Current Zoning: UR-C(CD) (urban residential – commercial, conditional)
Proposed Zoning: UR-C(CD) SPA (urban residential – commercial, conditional, site plan amendment)

Approximately 1.08 acres located on the west side of Providence Road, north of Ardsley Road, and south of Moravian Lane.

The petition proposes a site plan amendment to a previously approved petition, 2011-008, to allow for the site to be redeveloped with nonresidential uses.

**RZ-1.0**

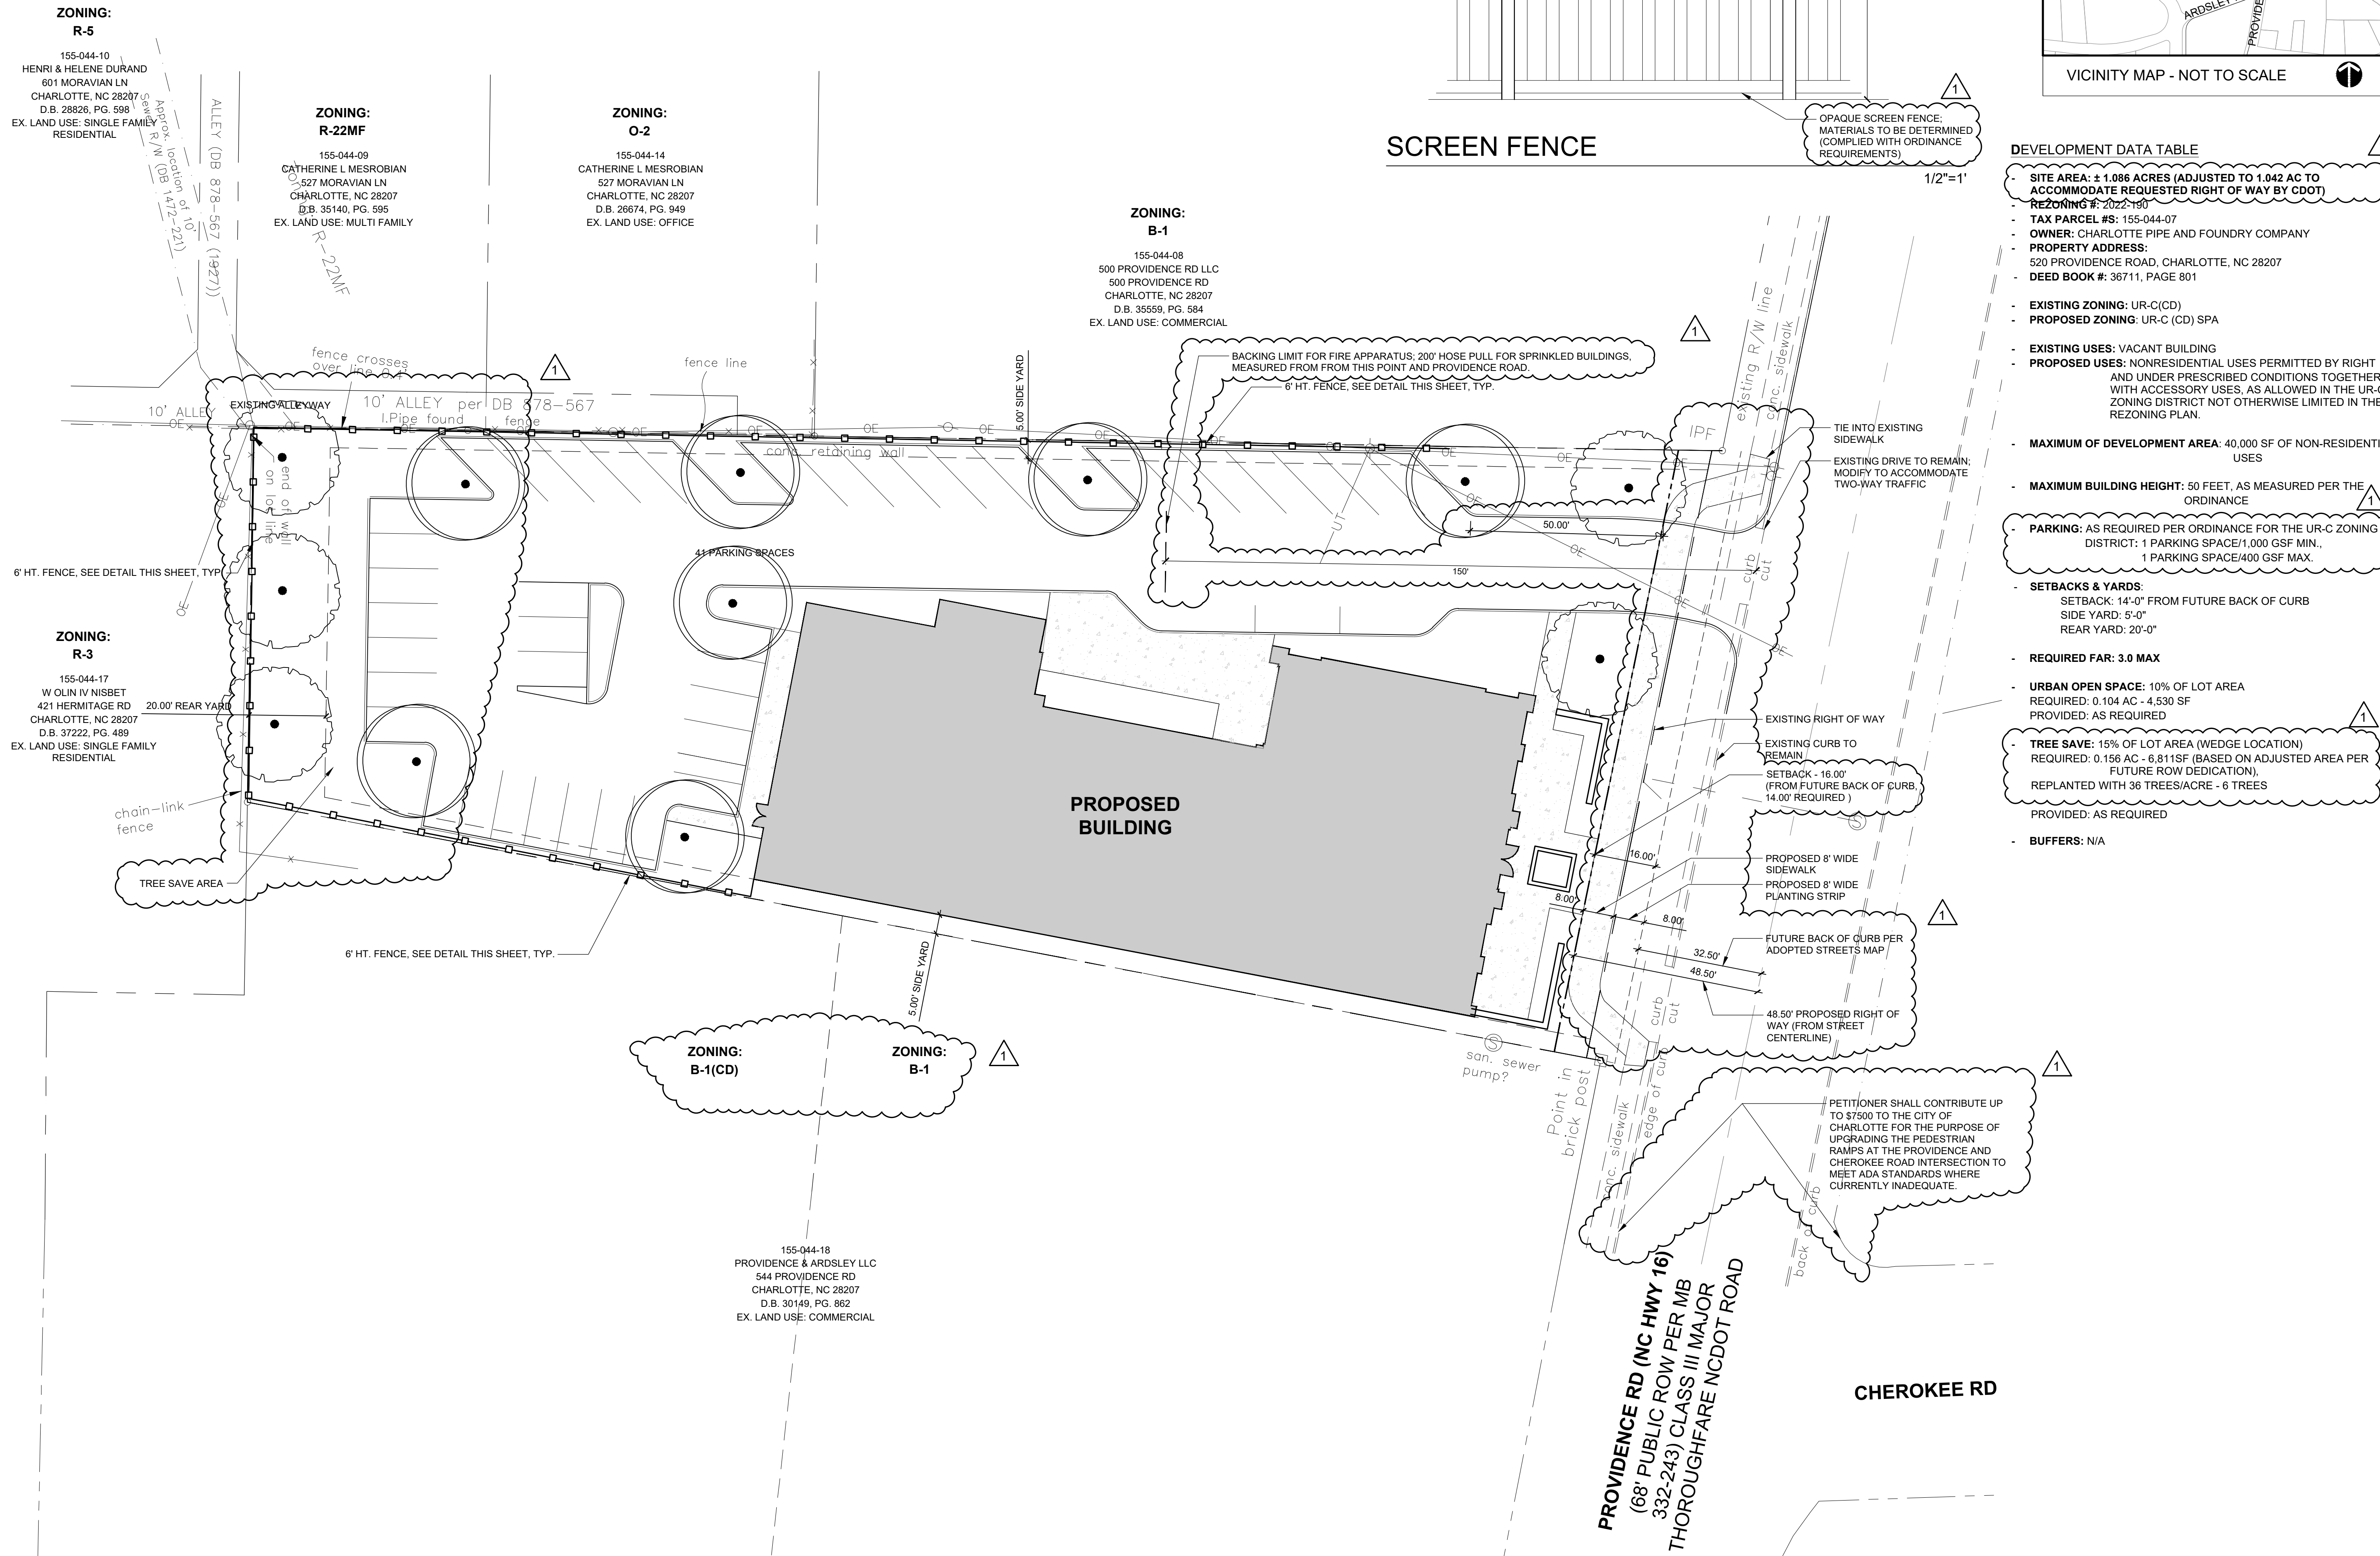
2. ~~Revise the parking spaces on the northern and southern boundaries so that they do not extend into the side yards.~~ **Addressed**

3. ~~The site plan shows a fence along a portion of the southern boundary, but the conditional notes only mention fencing on northern and southern boundaries. Clarify fencing commitments and update the notes as needed.~~ **Addressed**
